Reference: 19.589r05v01

16 February 2021

Re: Sirius Site - Proposed Alterations and Additions
2-60 Cumberland Street, The Rocks
SSDA Submission (Ref: SSD-10384)

Level 3-5 (Ground level)
Swept Path Analysis
8.8m MRV
Top: Entry Movement Bottom: Exit Movement

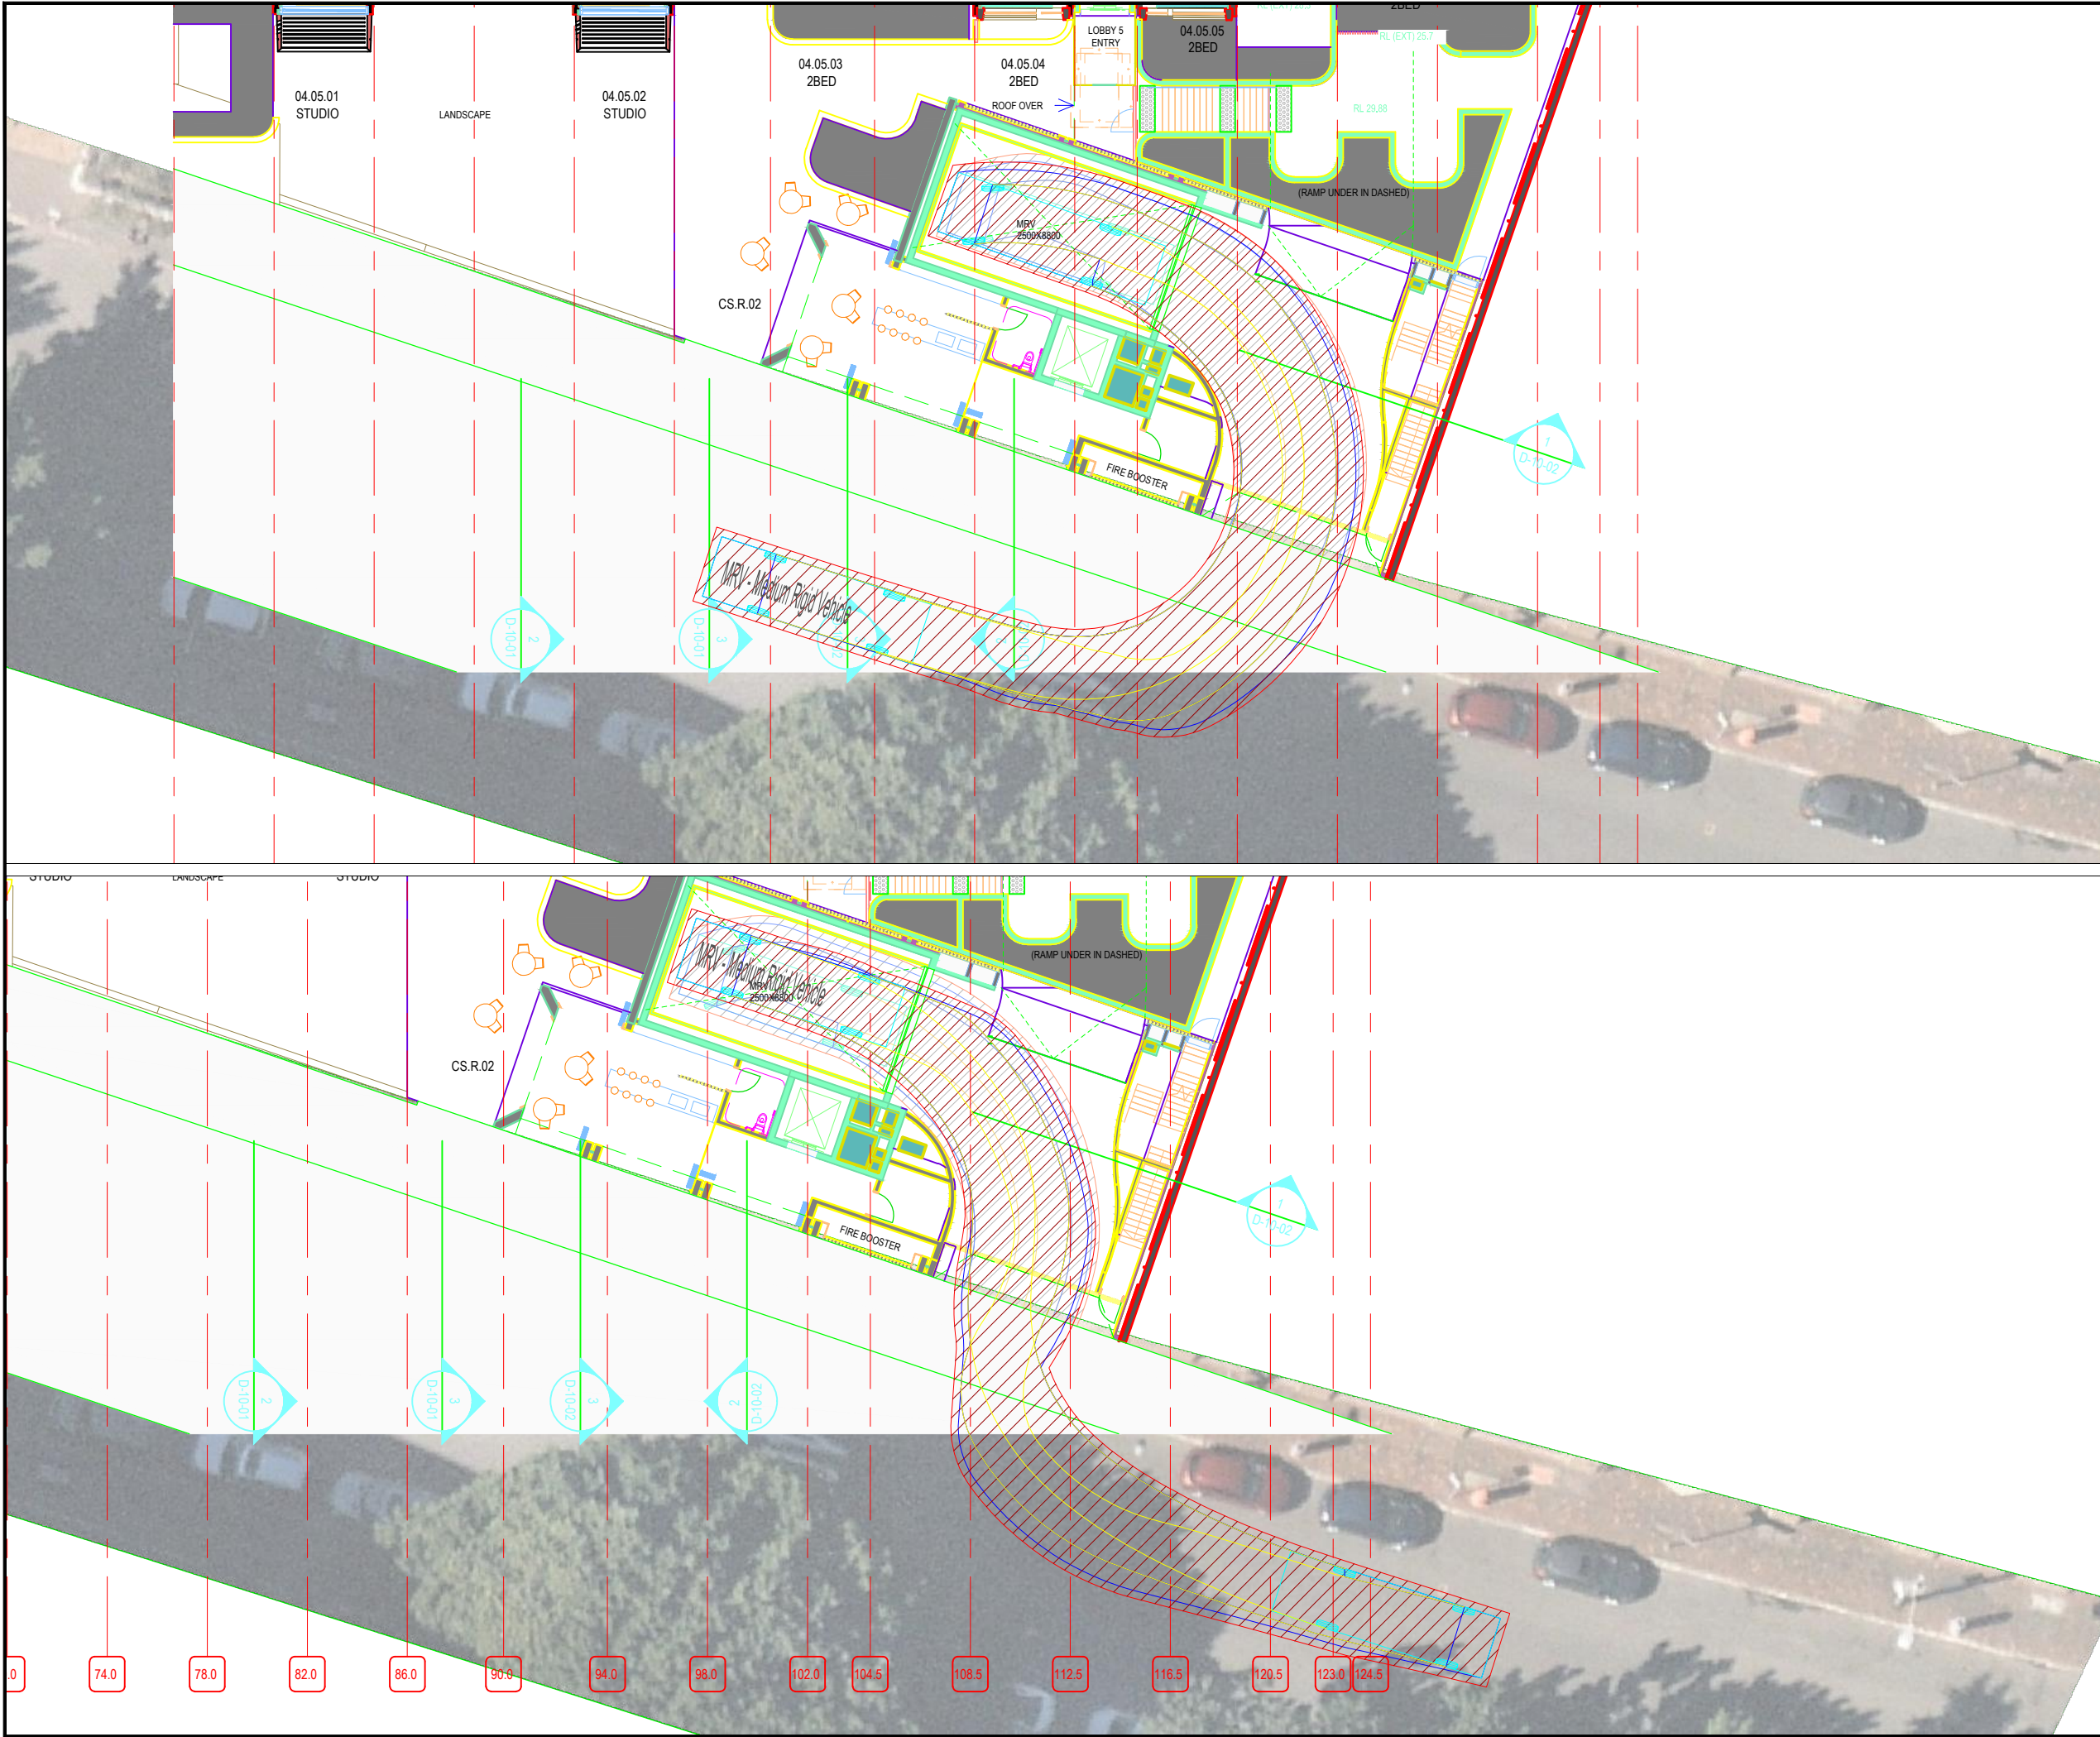
Given the proposed development involves a residential land use, the loading and service vehicle arrangements should be designed to accommodate Council's waste vehicle in accordance with the provisions of Sydney DCP 2012.

All servicing is proposed to be undertaken using service vehicles up to an 8.8m medium rigid vehicle (MRV) and all waste collection is to be undertaken using a private waste collection vehicle (7.5m rigid vehicle provided by a private waste collector). This arrangement is considered acceptable in the circumstances for the following reasons:

- *The development is physically (geometrically) constrained and is unable to accommodate a 9.25m Council Waste Collection vehicle onsite.*
- *The proposed loading bay system (including lift and turntable) incorporates access for vehicles up to an 8.8m MRV, thereby accommodating most removalist and service vehicles.*

BASEMENT B2b-B2a

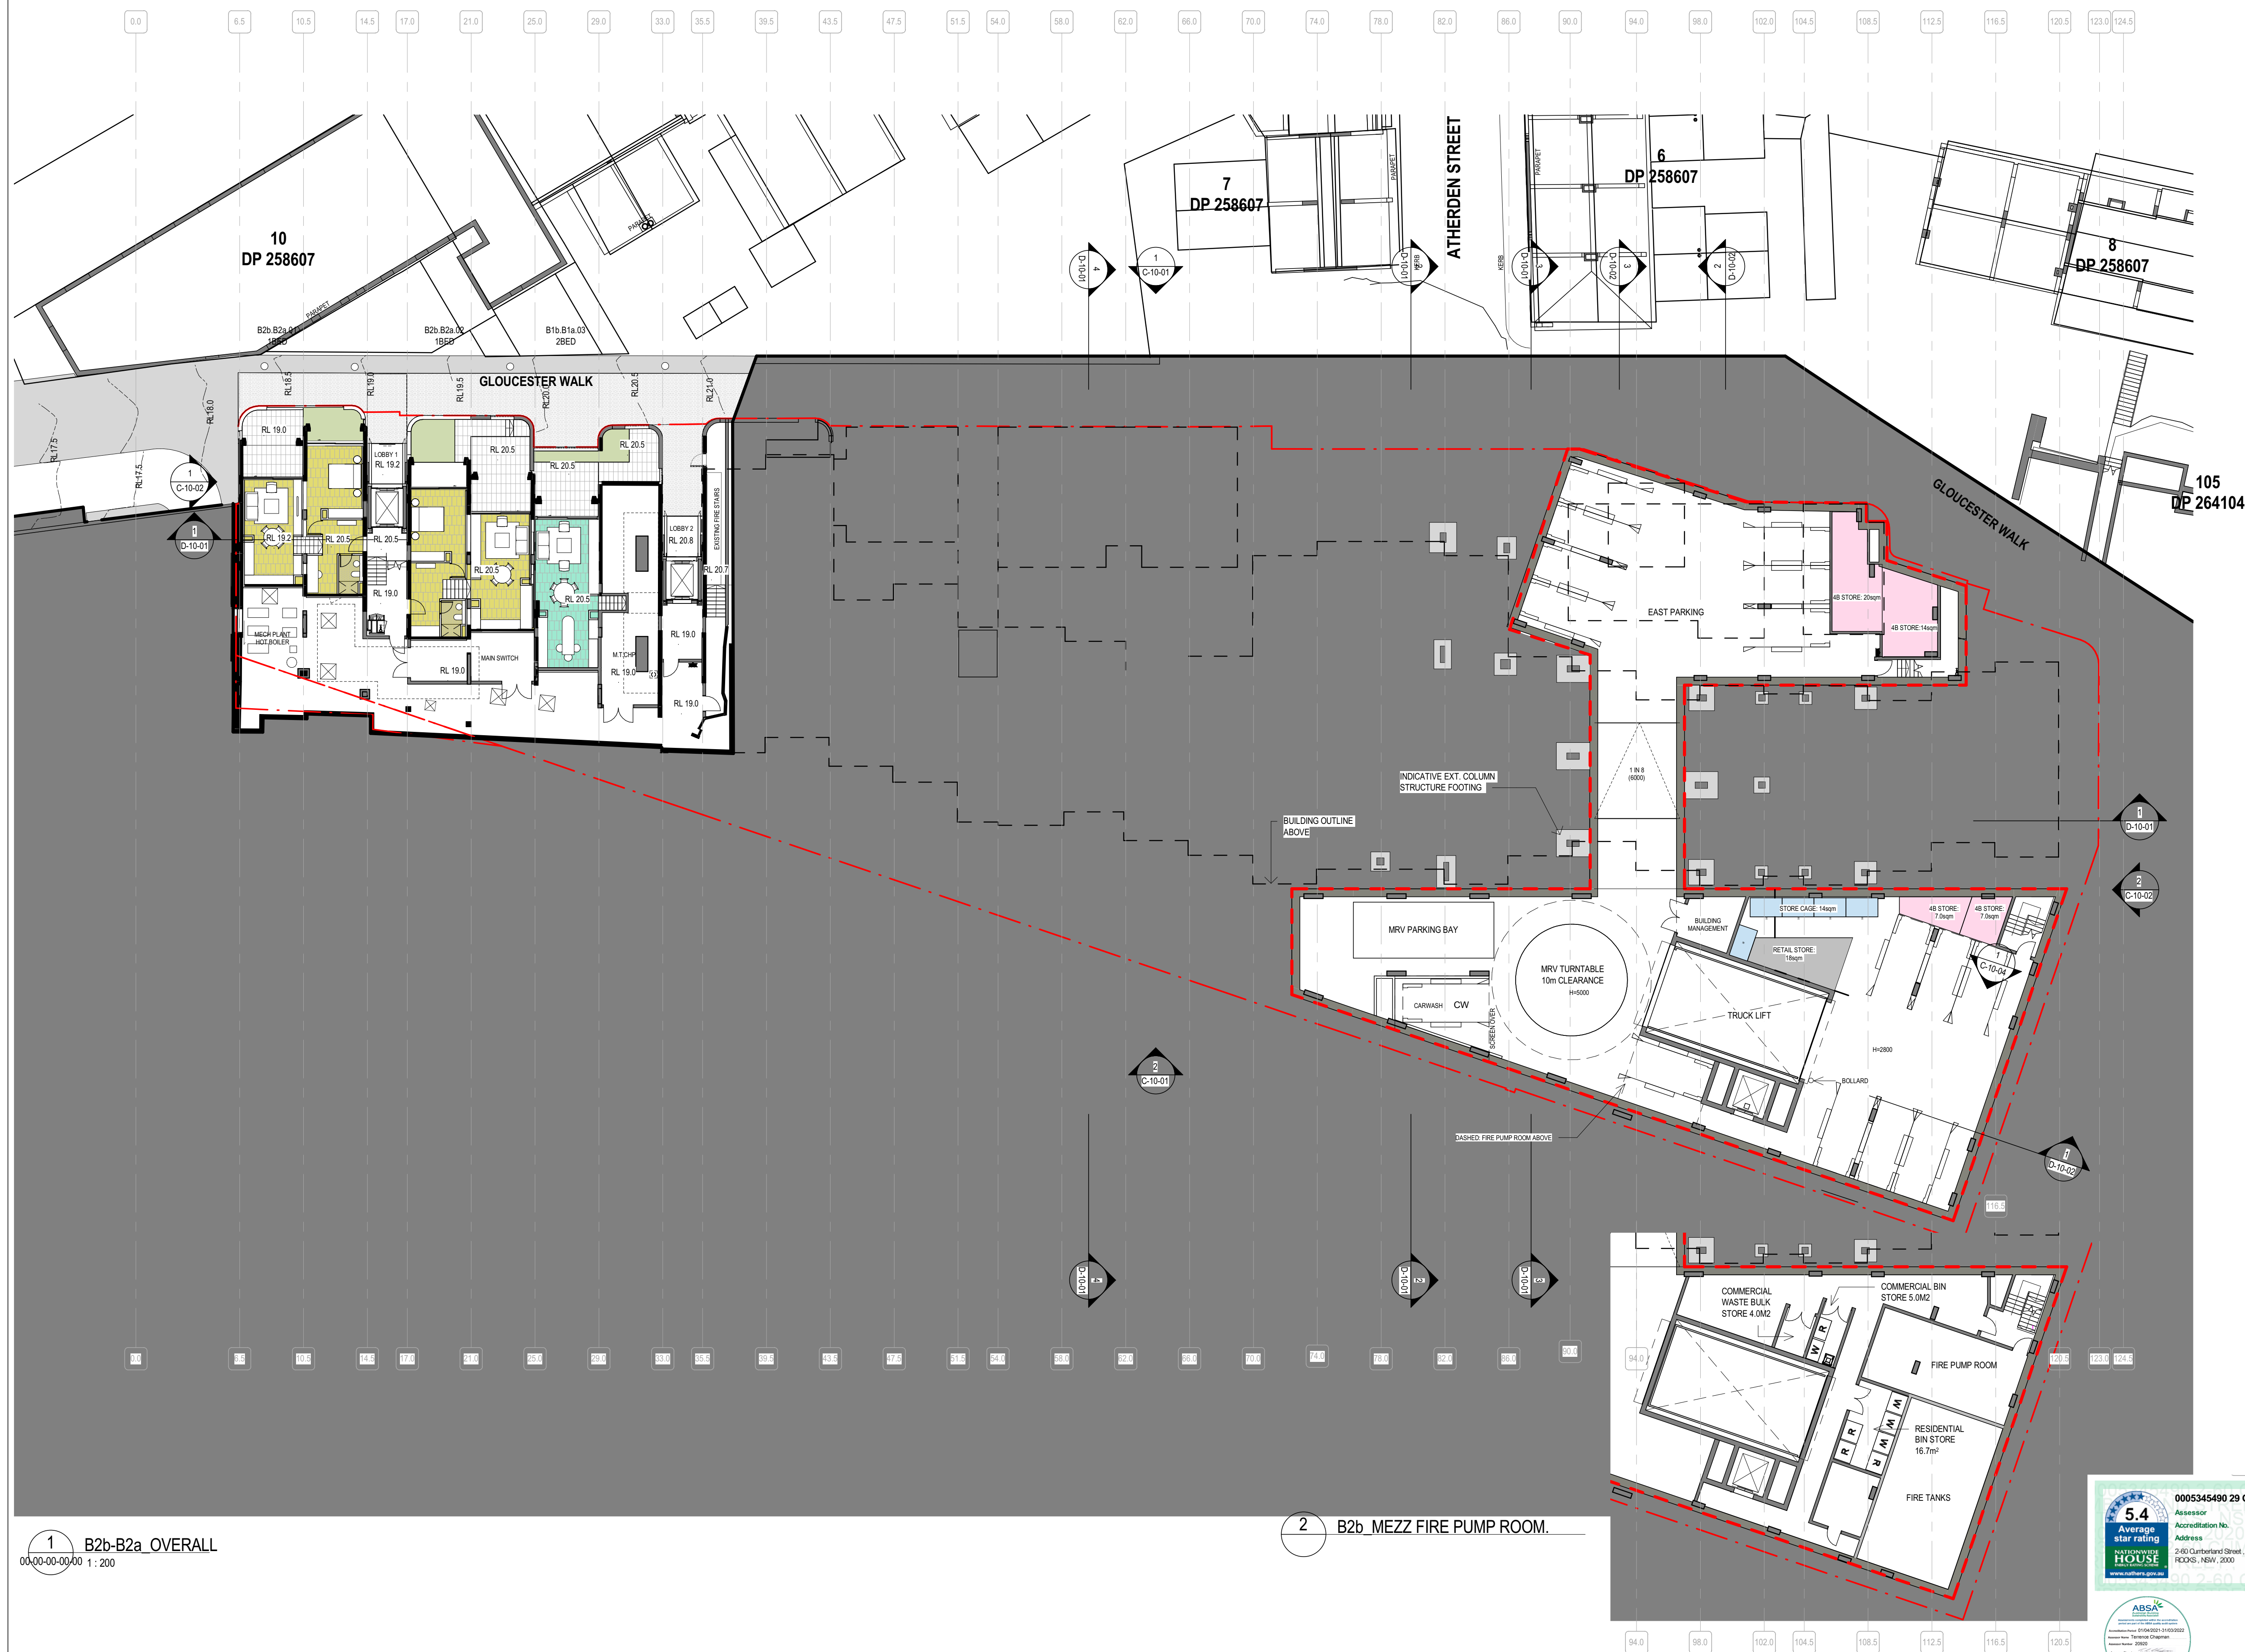
Section 5.5 of the Traffic Impact Assessment prepared to support the development application states that a loading bay is provided within Basement 2b and is accessed via a truck lift from the Cumberland Street frontage.

No information is provided to demonstrate that the proposed loading dock space will be adequate to accommodate the freight and servicing demand for the development.

- *The applicant provides details in relation to the demand and management of service bays for the residential, retail and commercial components of the development as part of the response to submissions; and*
- *The applicant be conditioned to prepare a Loading and Servicing Management Plan in consultation with TfNSW, prior to the issue of any Construction Certificate.*

As referenced above, Council provided in principle support for the proposed waste management strategy as noted in Attachment 1. This arrangement relies on private waste collection using up to an 8.8 metre medium rigid vehicle.

As per the Proposed Waste Collection and Servicing Arrangements Letter, advice provided by Foresight Engineering, states that based on the City of Sydney residential waste generation rates, the estimated total weekly waste and recycling truck movements are four times per week (being twice per week for general waste and twice per week for recycling). Servicing for the modest retail/commercial area is expected to be minimal and infrequent. Access for removalist vehicles will be via appointment and outside of the expected servicing times. The demand for servicing and refuse collection is considered to be negligible and infrequent. As a result, all servicing and refuse collection demands will be accommodated on-site with no reliance on on-street.

A Loading and Servicing Management Plan may be developed prior to Construction Certificate (CC) stage in response to a suitable condition of consent.
